**EPC STORMWATER REVIEW COMMENTS ARE SHOWN IN ORANGE BOXES WITH BLACK TEXT**

**TITLE PAGE**  
**EROSION AND STORMWATER QUALITY CONTROL PLAN**  
**Aura at Crossroads Electric and Gas Main Installation**

PCD Filing No: CDR-22-013  
 Prepared By: JPH  
 Date: June 2022

Project No: PCD File No.: CDR-22-013	Figure Number 4 CENTRAL
Prepared By: J HOUGHTON	
Date: SEPTEMBER 2022

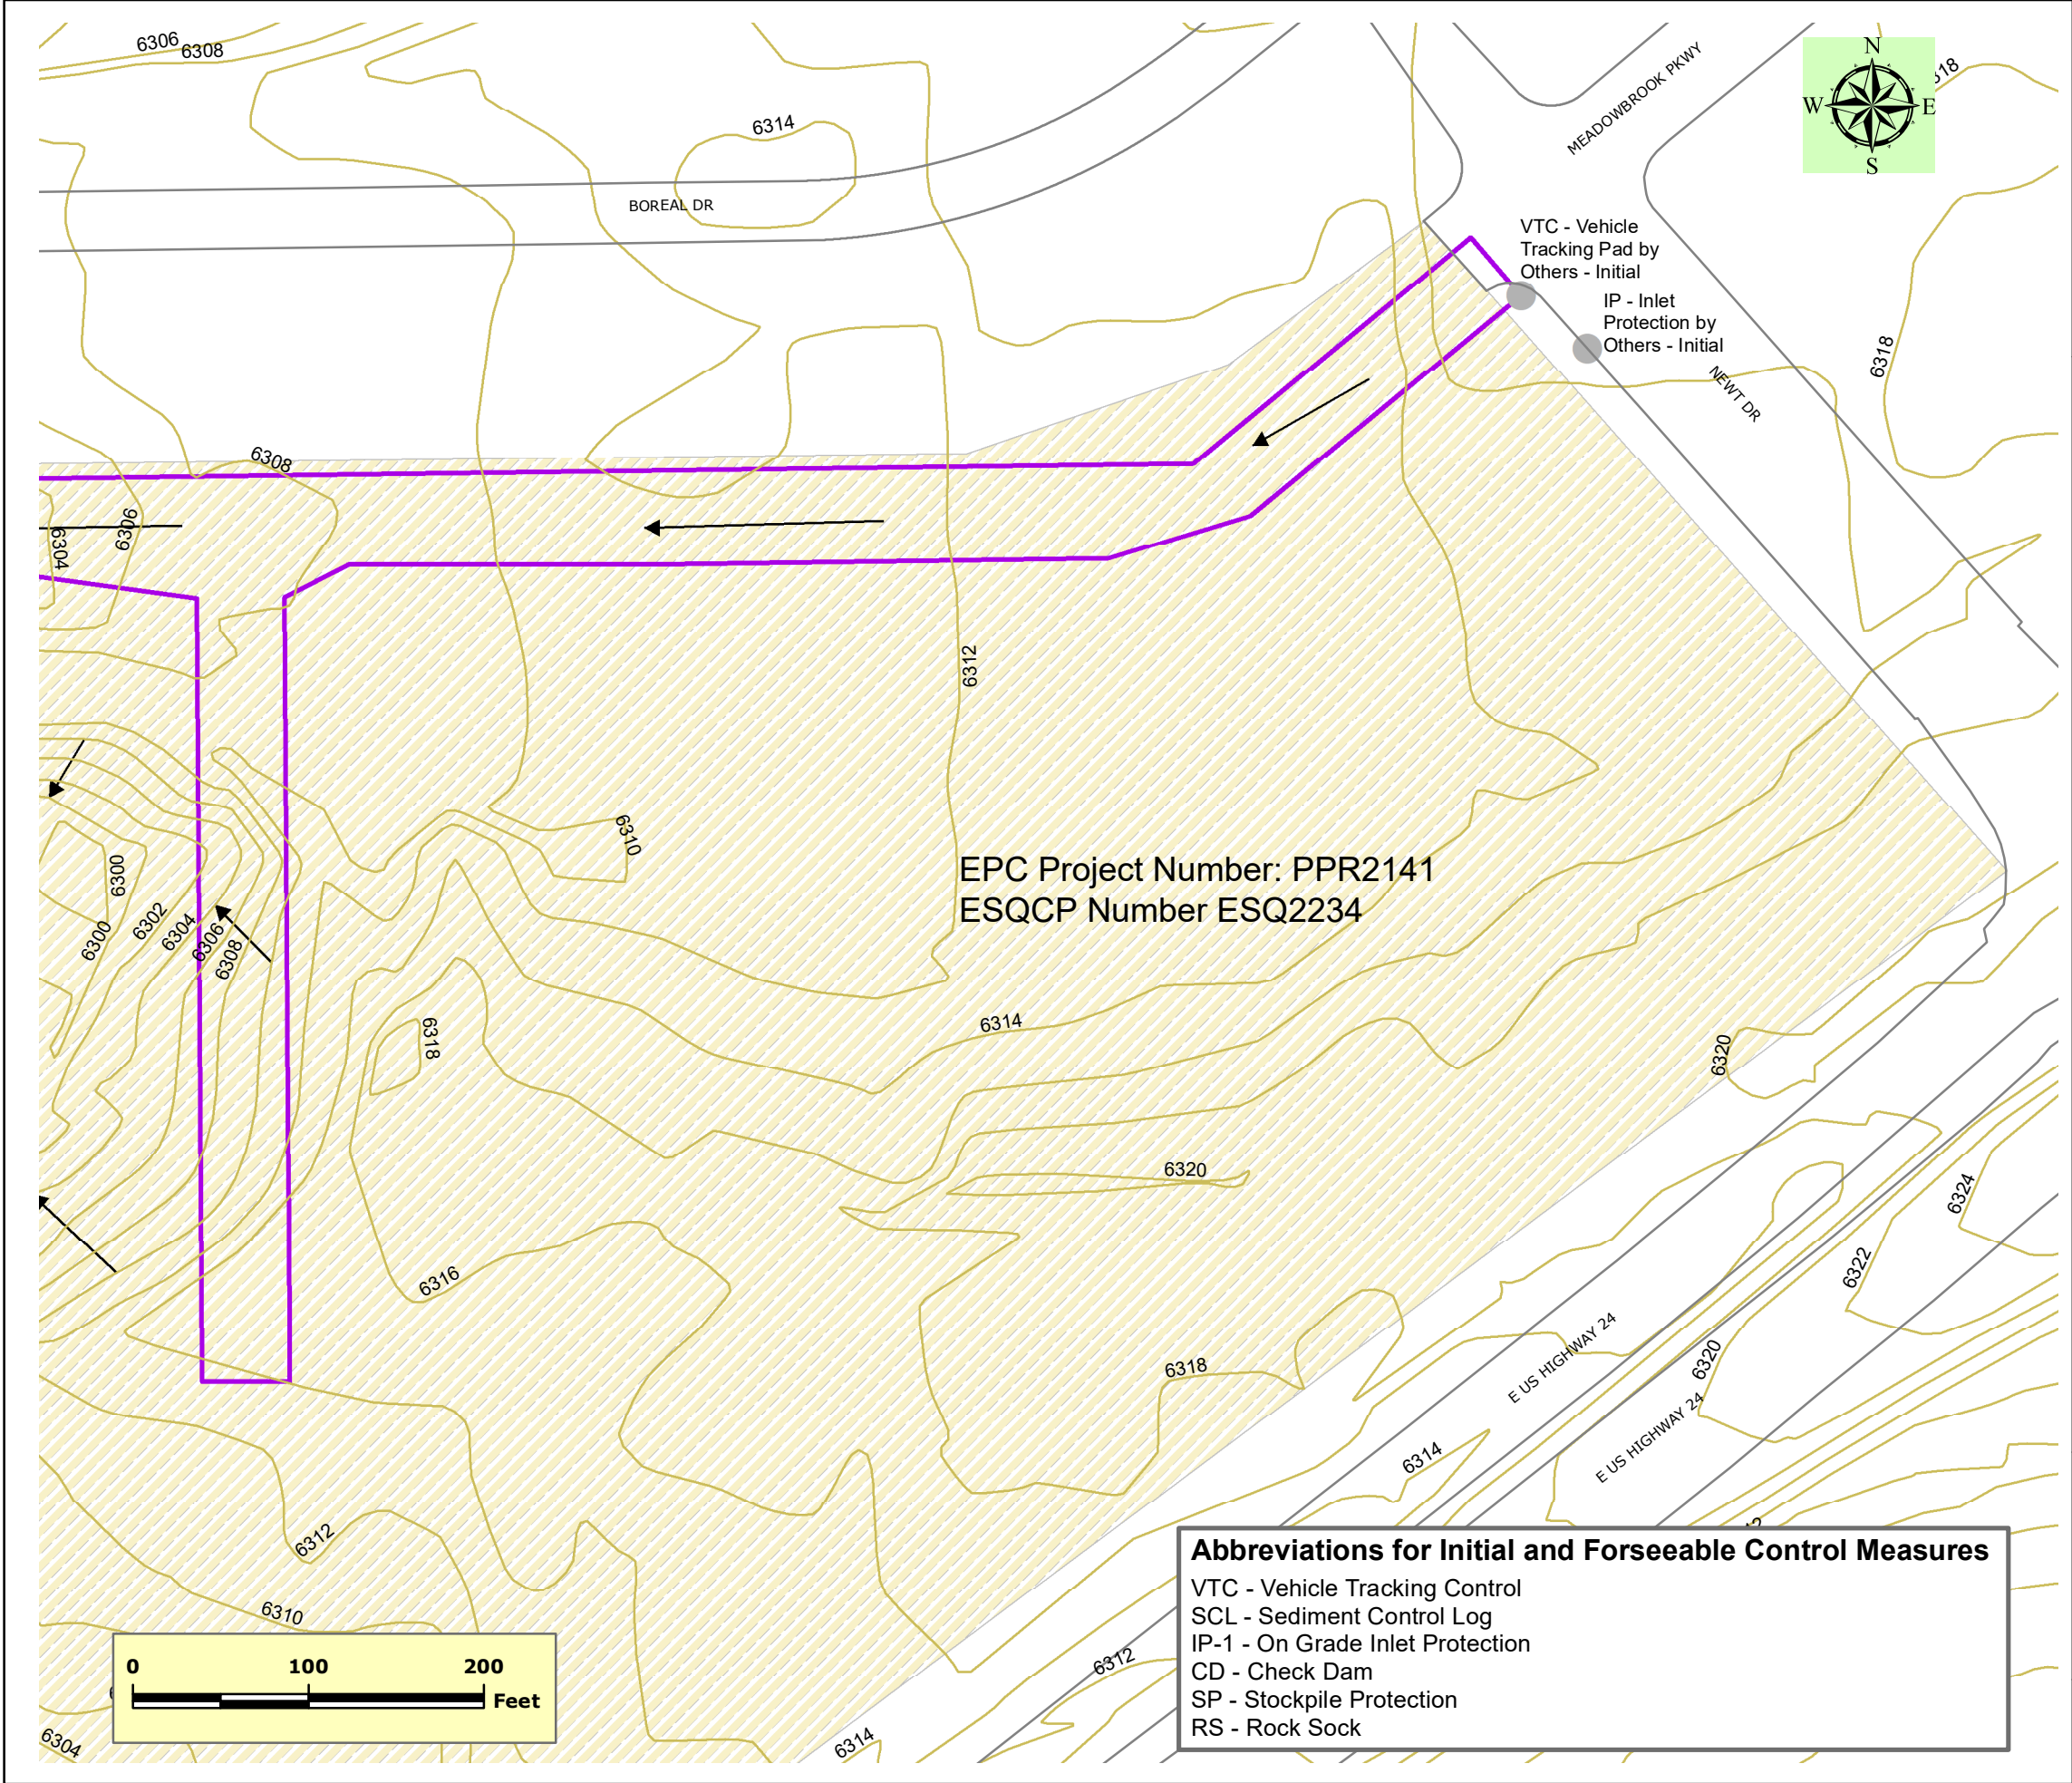
show limits

show the limits of  
silt fence

Project No: PCD File No.: CDR-22-013	Figure Number 4 EAST
Prepared By: J HOUGHTON	
Date: SEPTEMBER 2022

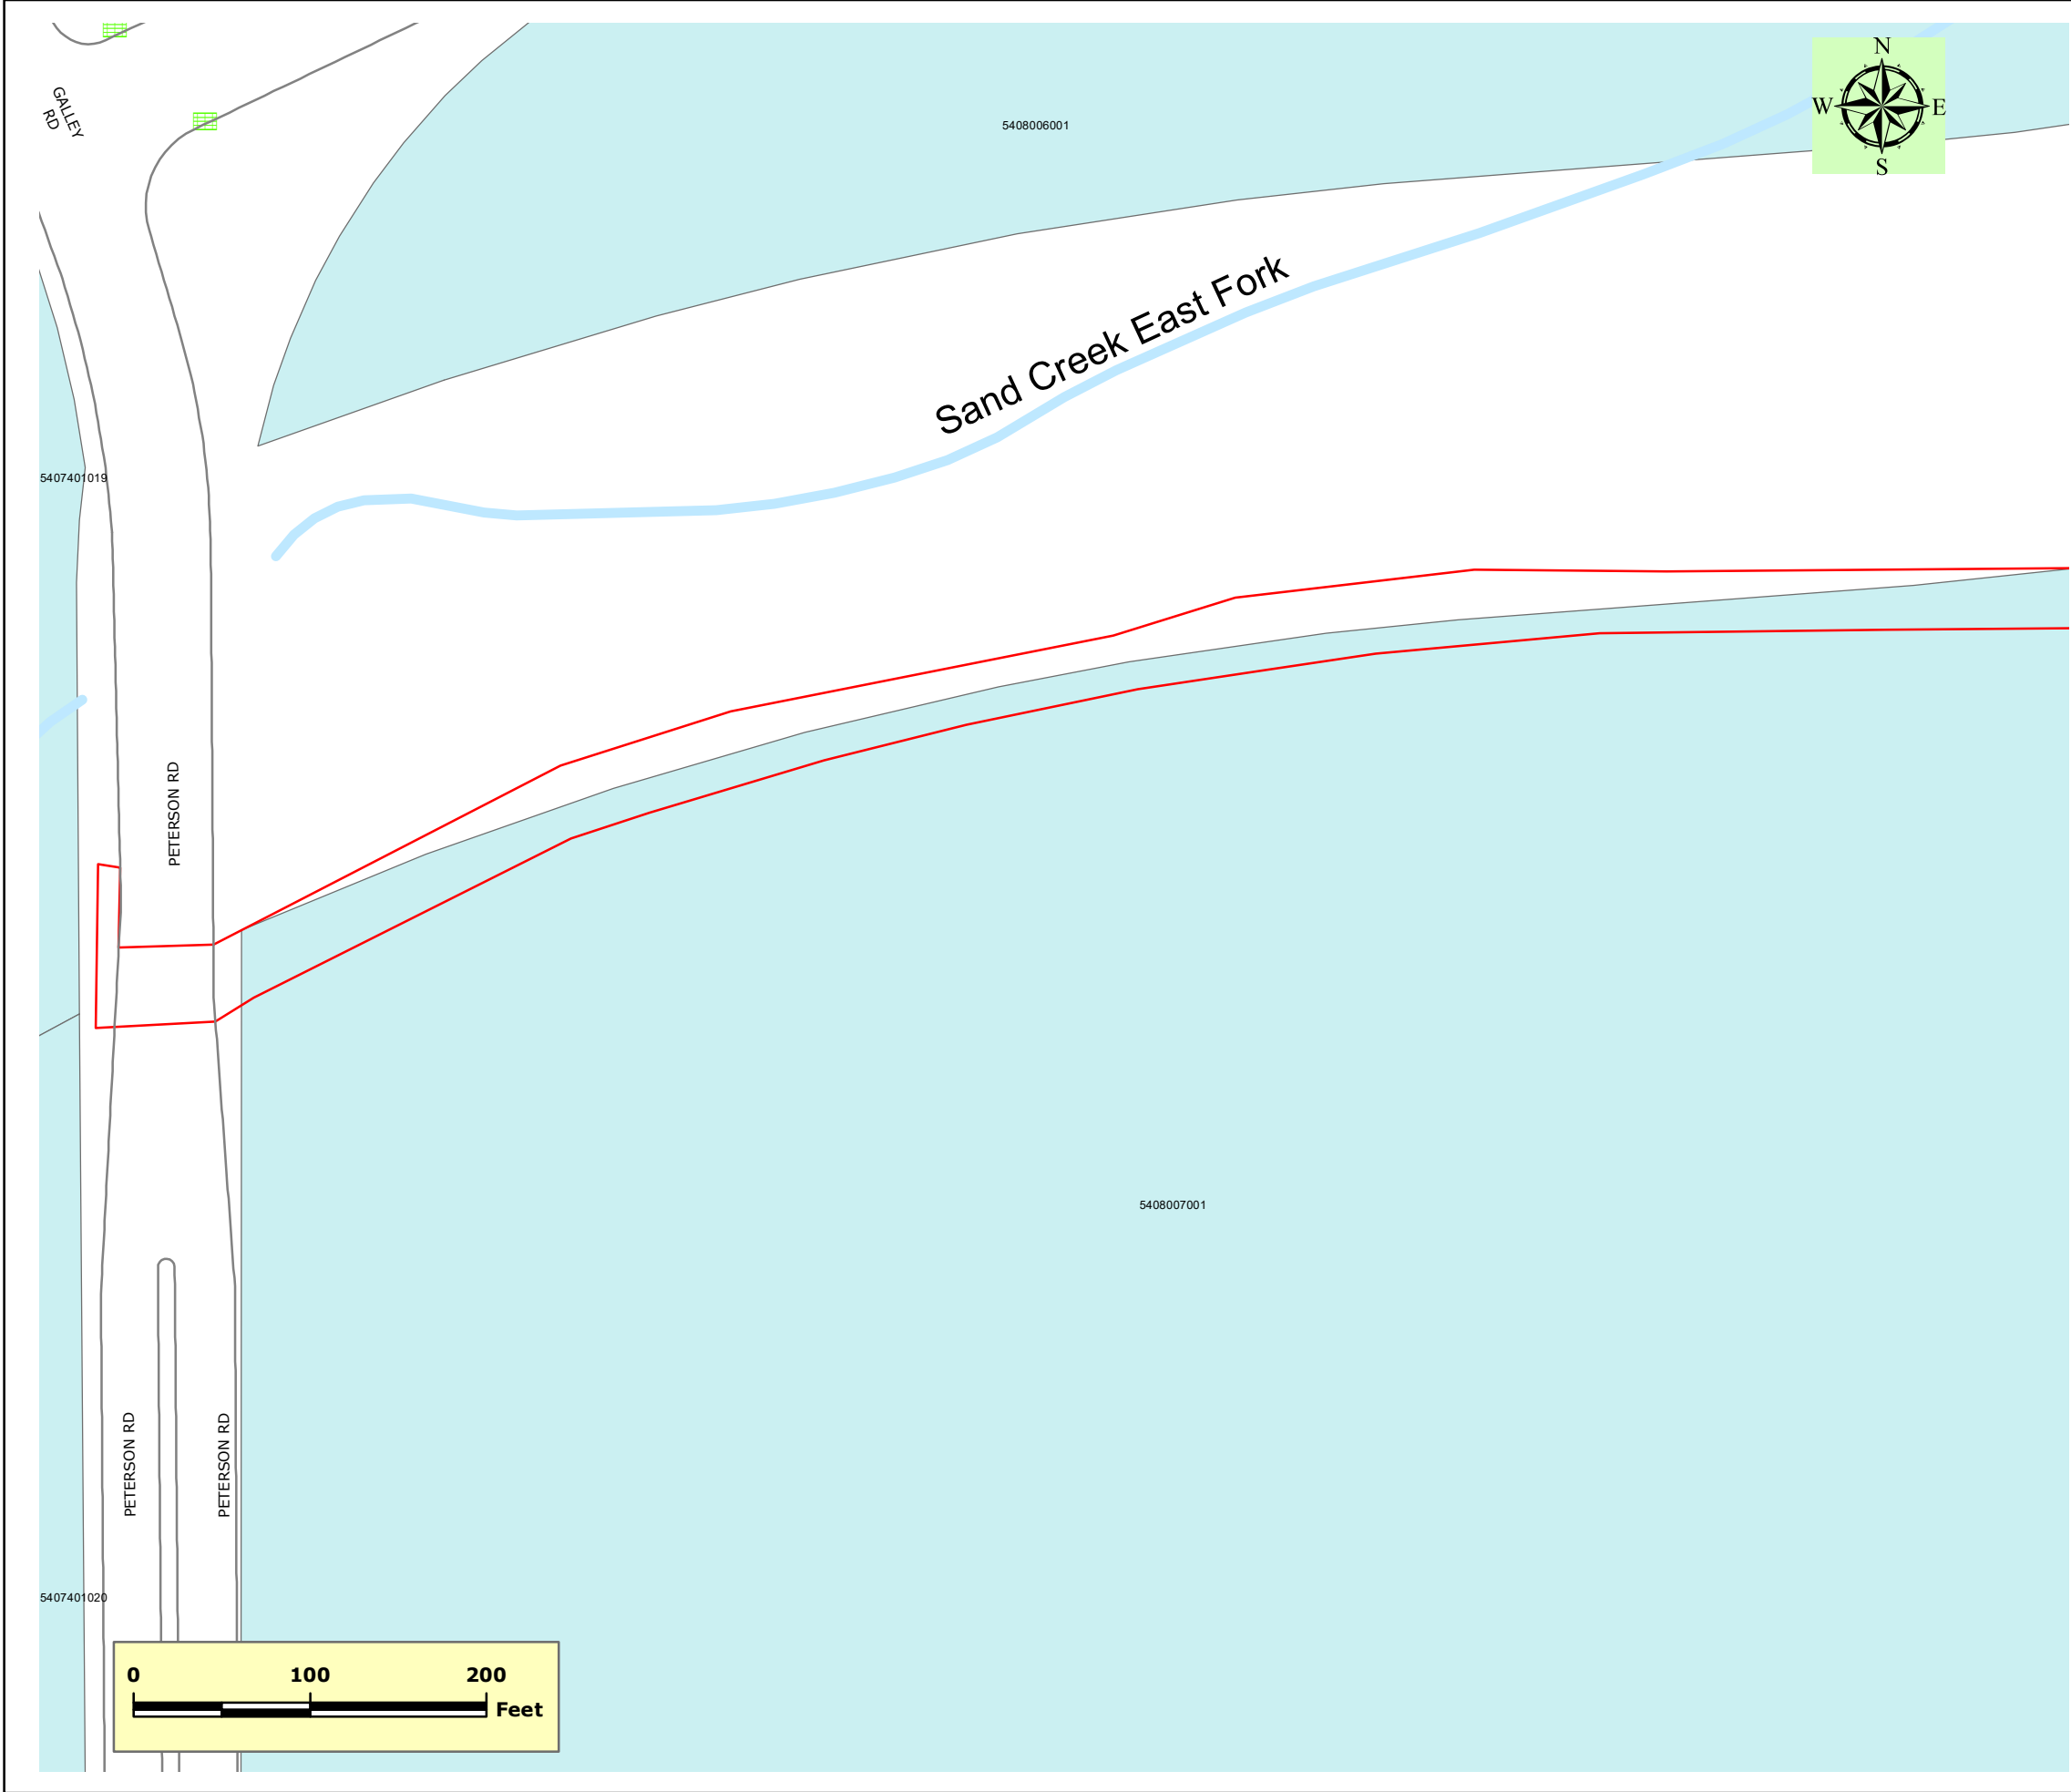
flow direction doesn't seem accurate. show on figures with contours. Include flow arrows outside the construction area

Please note that it is already installed

What are these in reference to?

Label all proposed temporary construction BMPs by phase of implementation (initial, interim, final)
